Please ask for: Ms Iqraa Malik
Email: iqraa.malik@terraquest.co.uk
Telephone: 01212341390
Our Ref: Y/62/20/HH
Your Ref:
Date: 24th July 2020

Application for Planning Permission for Works or Extension to a Dwelling

Development: Residential annexe
Location: 1 Church Farm Cottages Church Road Yapton BN18 0EP

Project:	
Proposed accommodation; The Old Dairy, 1 Church Farm Cottages, Church Road, Yapton BN18 0EP	
Drawing:	
Plans and elevations as proposed	
For:	
Mr. & Mrs. P. Williams	
Drawn:	Date:
PKS	July 2020
Scales:	No:
1:50 1:100	2613/01/01
To scale when printed on A3

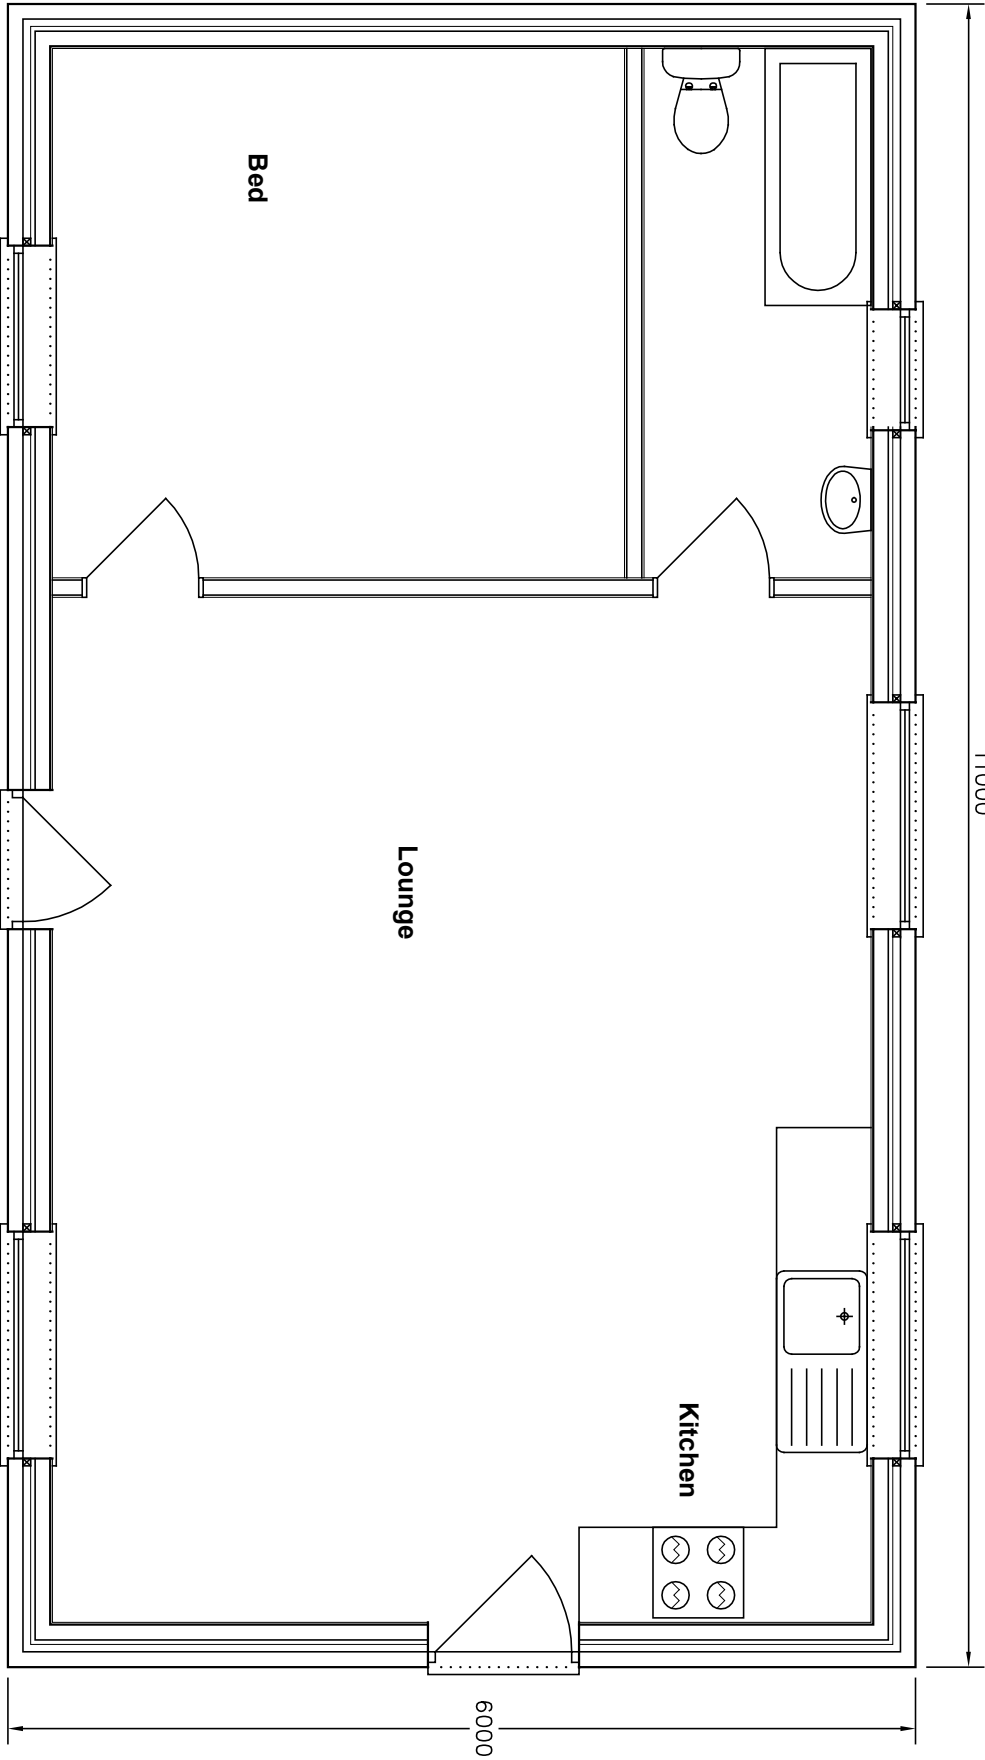
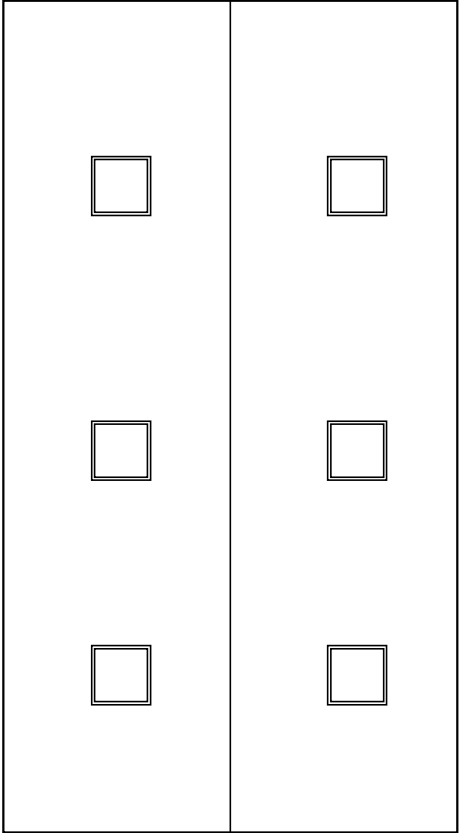
Floor Plans

Please submit clearly labelled proposed floor plans at a scale of 1:50 or 1:100. Further details can be found in the Validation Requirements List.

Elevations

Please submit clearly labelled proposed elevations at a scale of 1:50 or 1:100. Further details can be found in the Validation Requirements List.

Scales: **1:500** No: **2613/01/02**

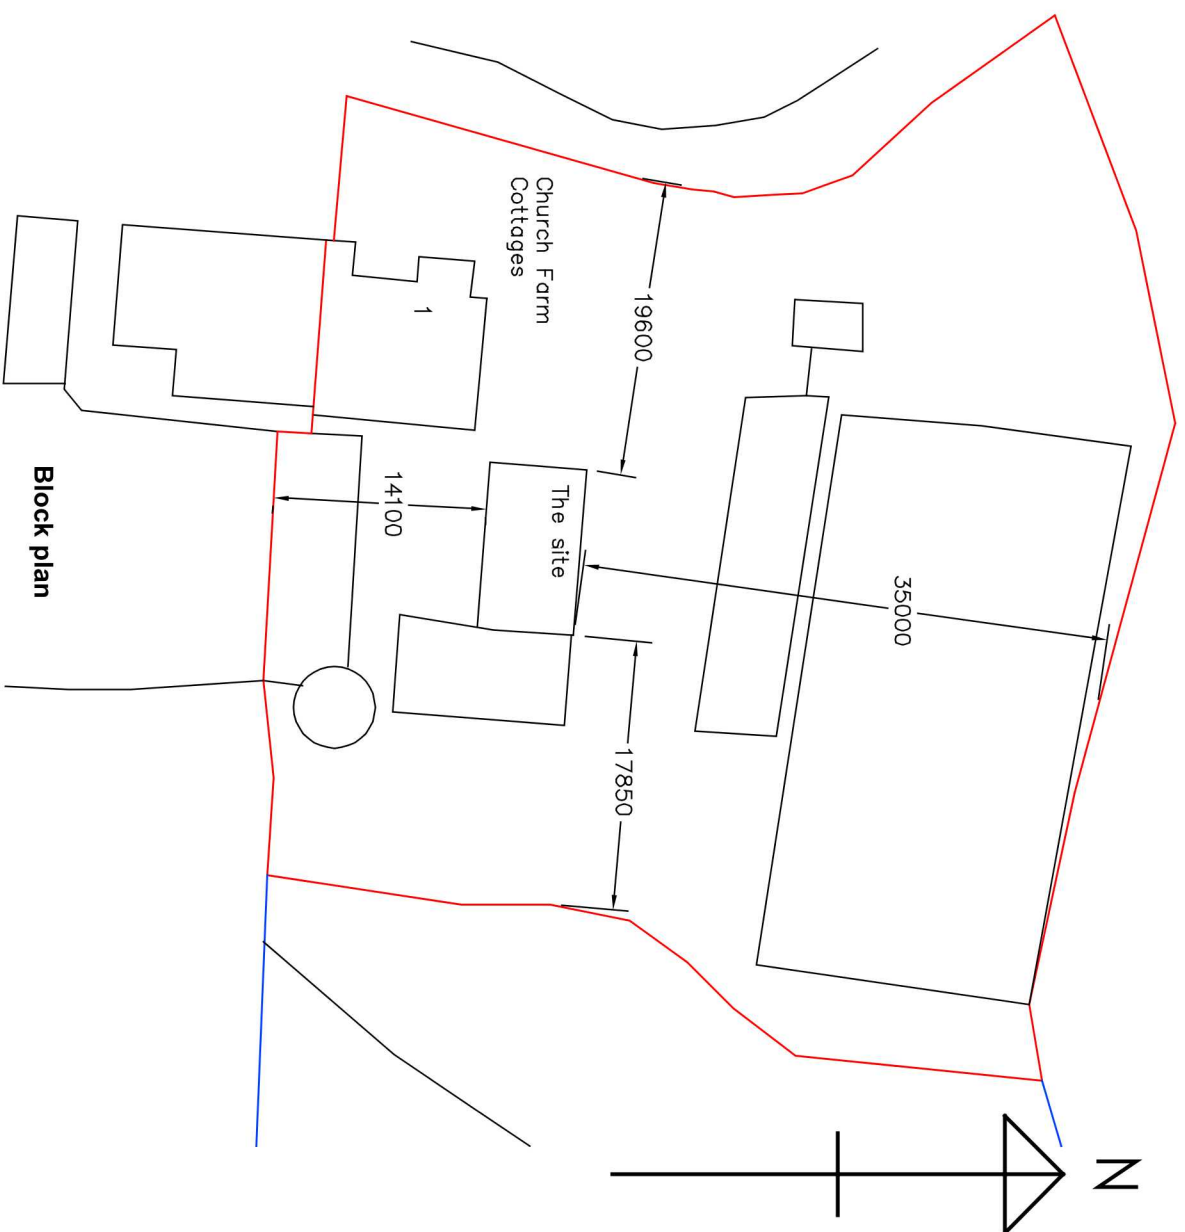
Block Plan

You are required to have dimensions from the proposed extension(s) to all site boundaries. Please amend.
